EL PASO COUNTY STORMWATER MANAGEMENT PLAN CHECKLIST

PPR 1844

**STORMWATER MANAGEMENT PLAN (SWMP)
STORMWATER BEST MANAGEMENT PRACTICES**

**LOT 13, OF THE CLAREMONT BUSINESS PARK
FILING NO. 2**

EL PASO COUNTY, STATE OF COLORADO
GRADING & EROSION CONTROL PLAN

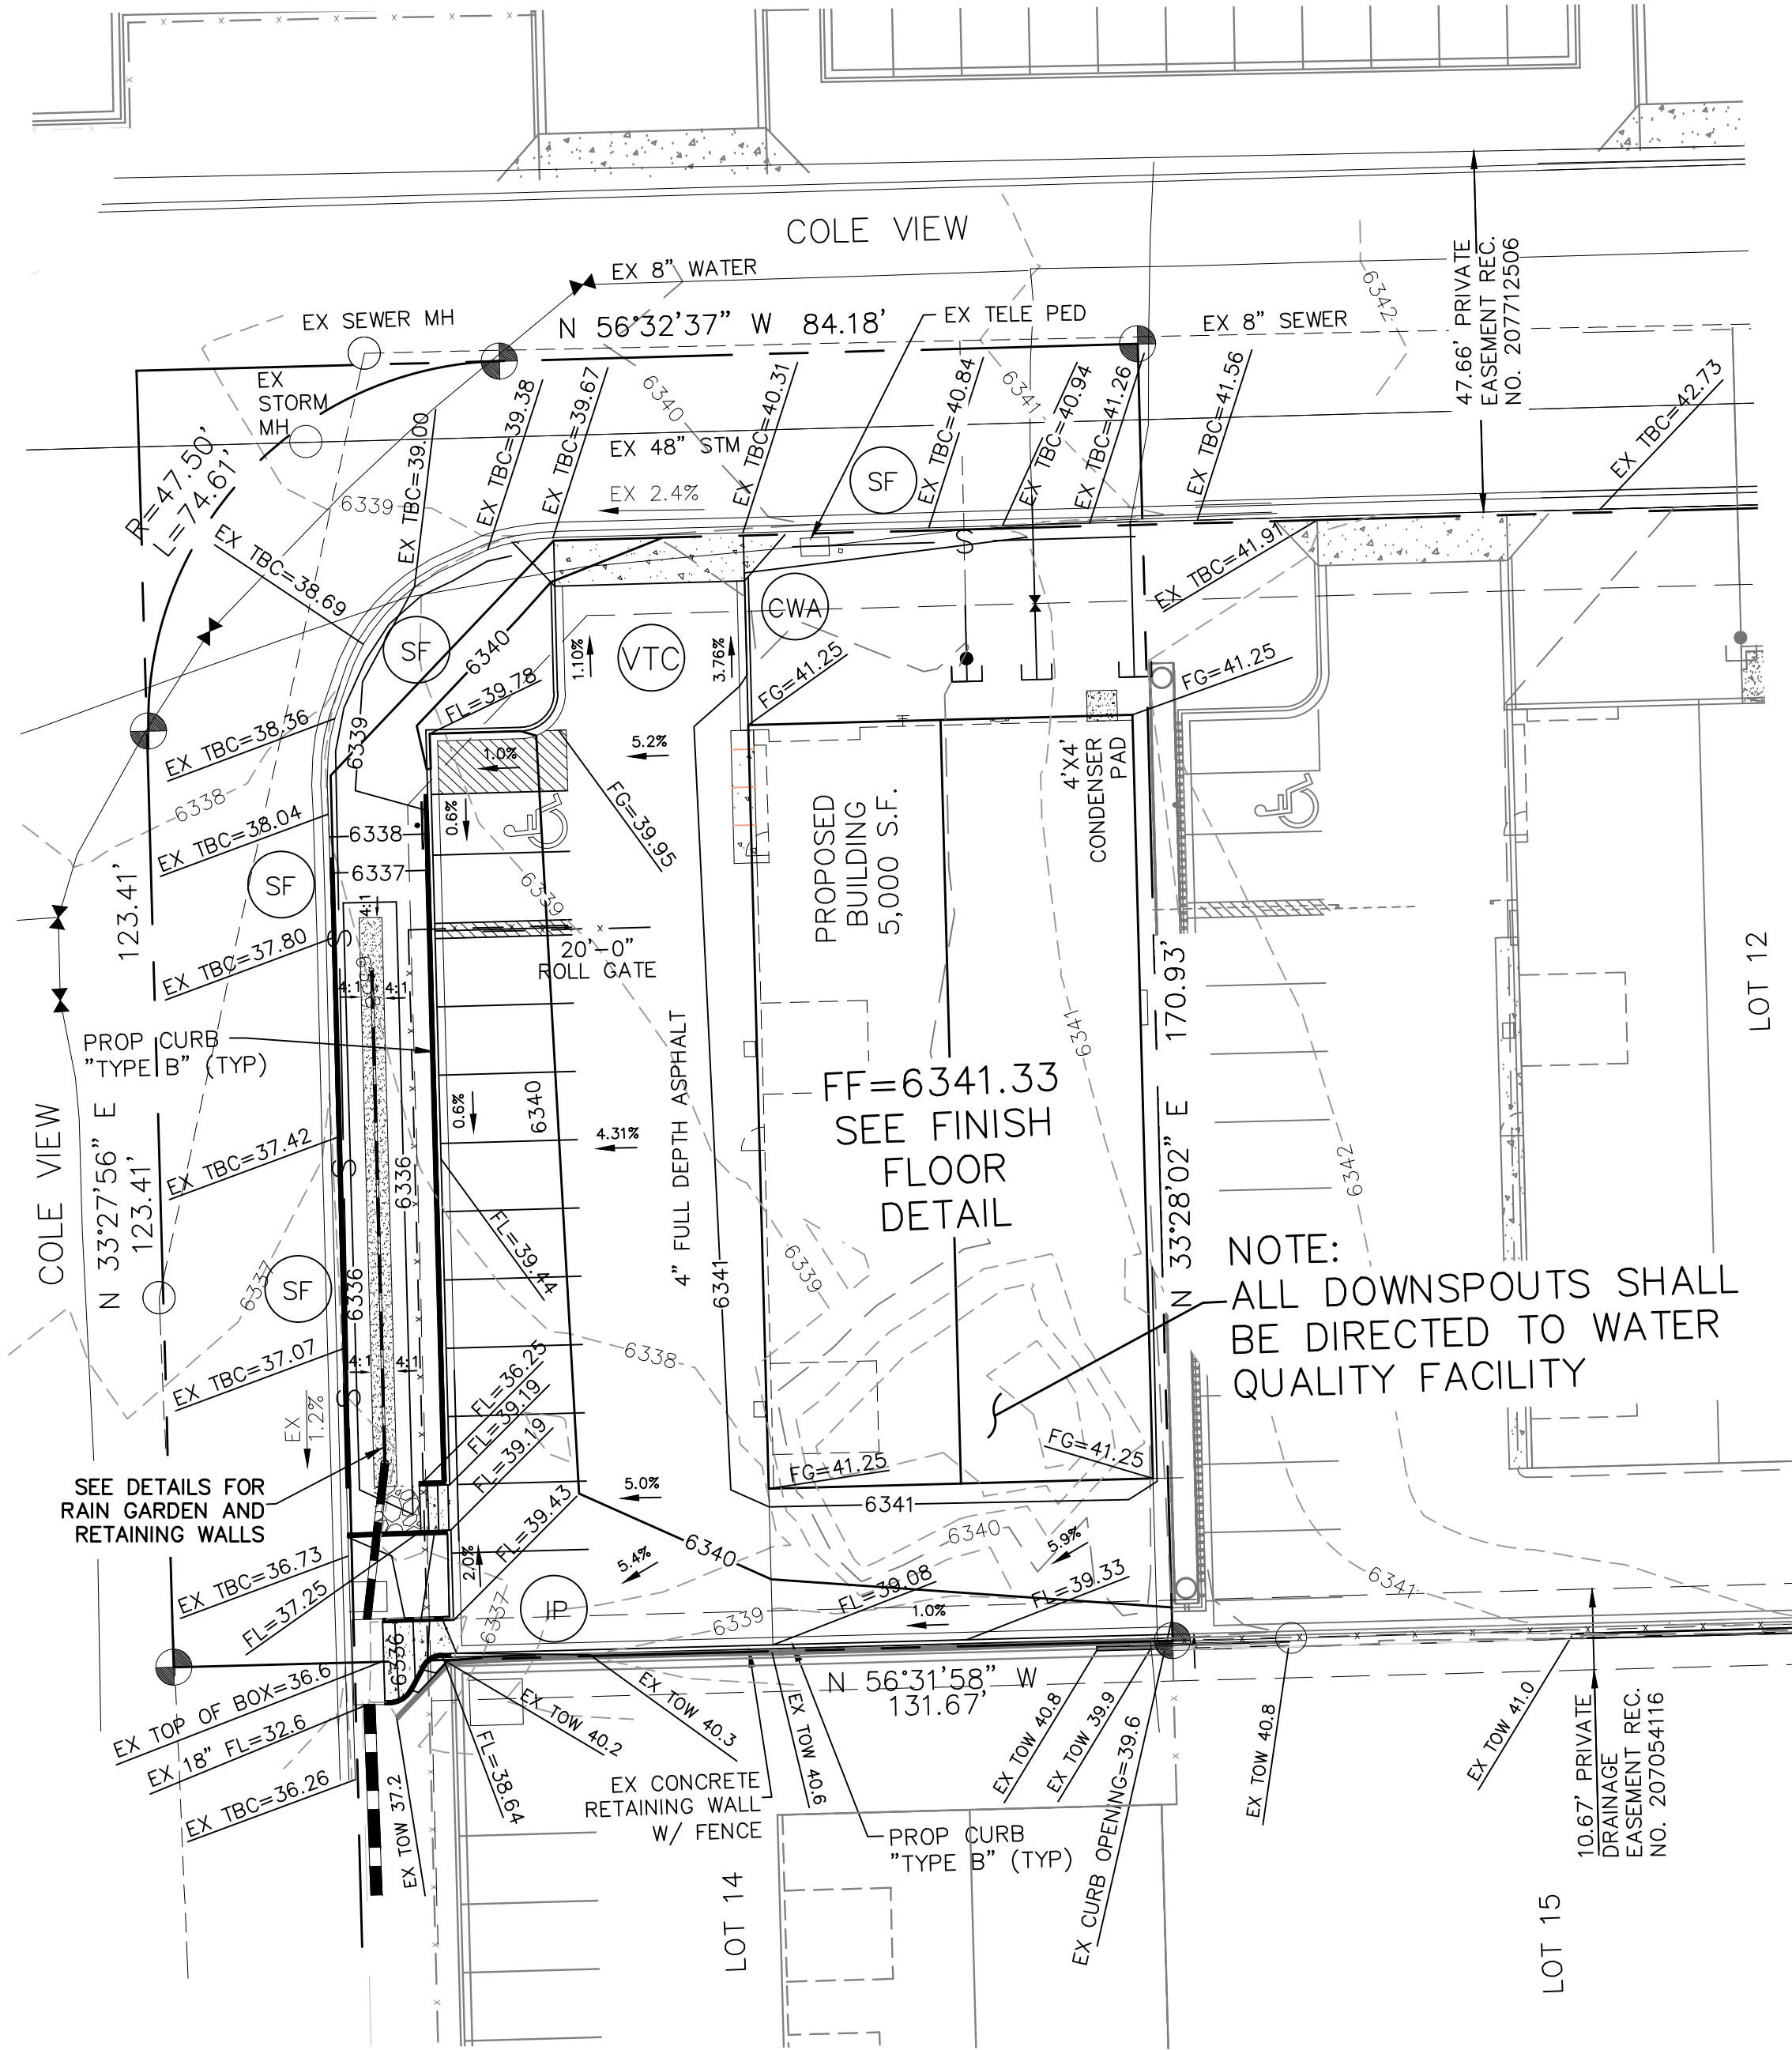
If BMP measures shown on the GEC are breached it would flow to the west onto Cole View
